Development Control
Ribble Valley Borough Council

App no: 24.0484

Address: Ramsgreave Bakery Pleckgate Road Ramsgreave

Proposal: Proposed demolition of existing warehouse structure and erection of two separate blocks of industrial units (use class B2/B8) comprising one block of five units, each with a mezzanine floor and one block of two units each with a mezzanine floor, including associated car parking and service yard.

Site Plan - as proposed, scale 1=200

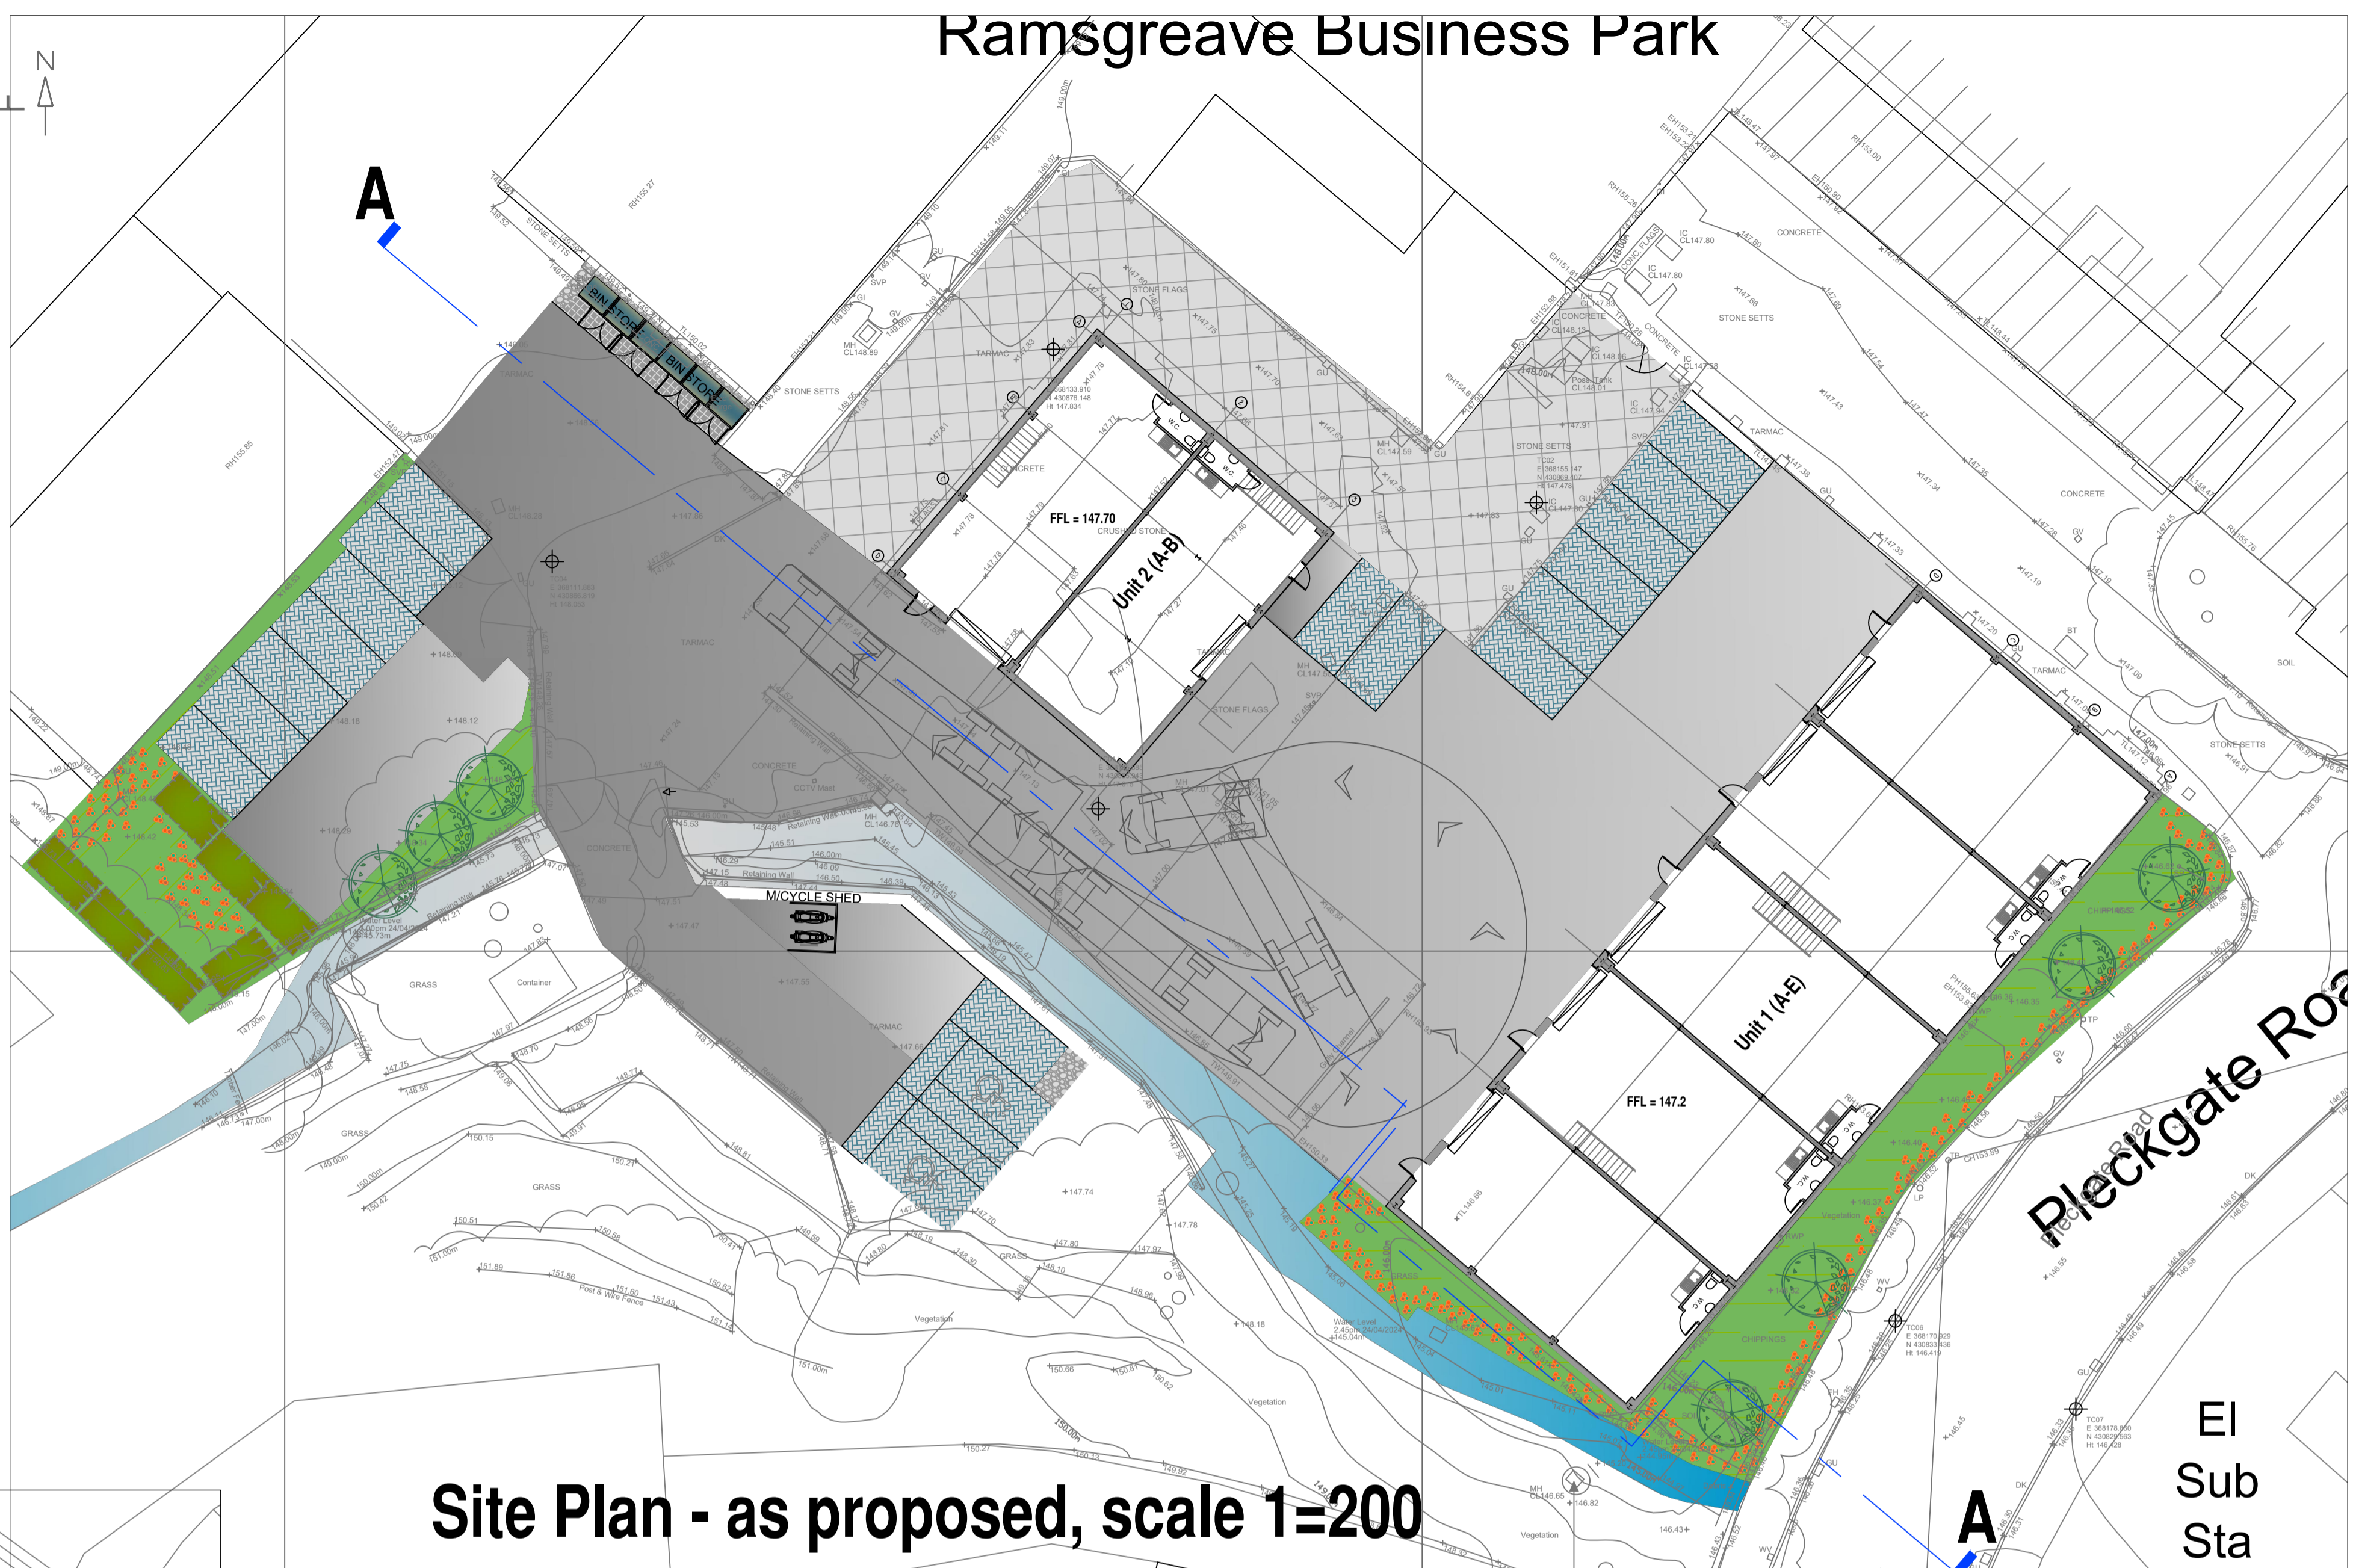
There are 17 car parking spaces proposed including 2 disabled parking bays. There are 2 motorcycle bays proposed and in addition a secure, covered cycle store is required for at least 2 bicycles.

As the end users are unknown, therefore we would apply the parking standards as a guide for a medium accessibility site and for the B2 use this equates to 9 spaces (1 space per 53sqm) and for the B8, 2 spaces (1 space per 235sqm). There is an over provision of car parking proposed however this is supported due to the constrained layout surrounding the site and this will prevent any over spill car parking onto the surrounding highway.

**Location Plan** 0 20 40 60 metres

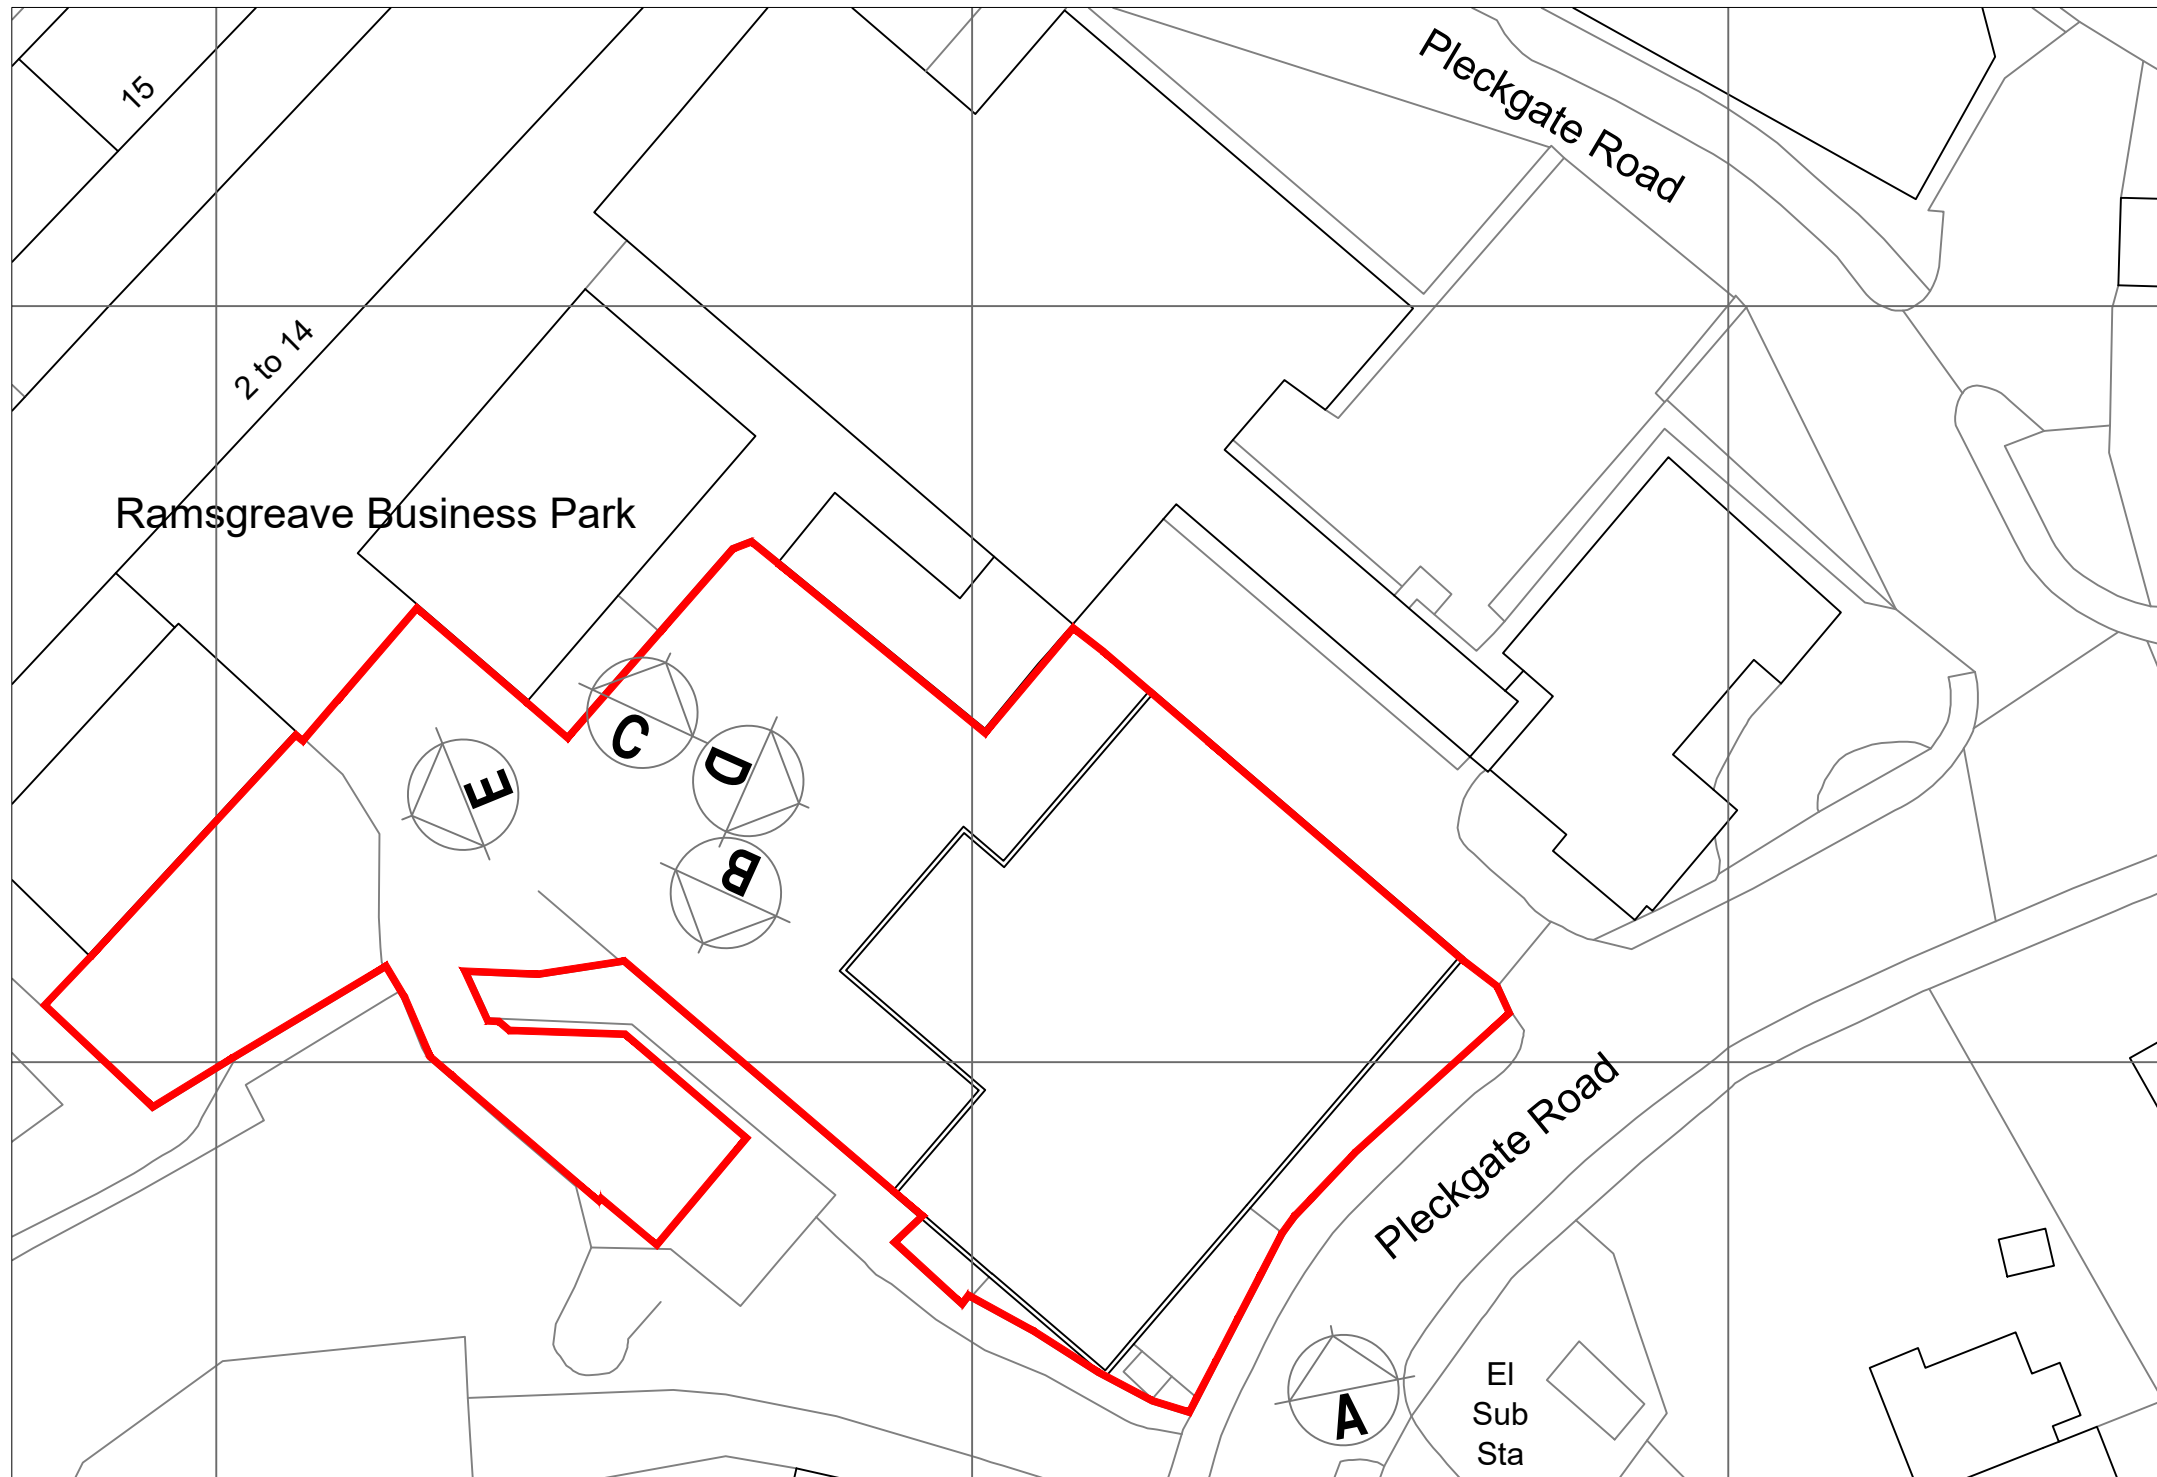
The full site access route up to Pleckgate Road should be included in the red edge and the applicant should demonstrate that they have a right of vehicle access over the land.
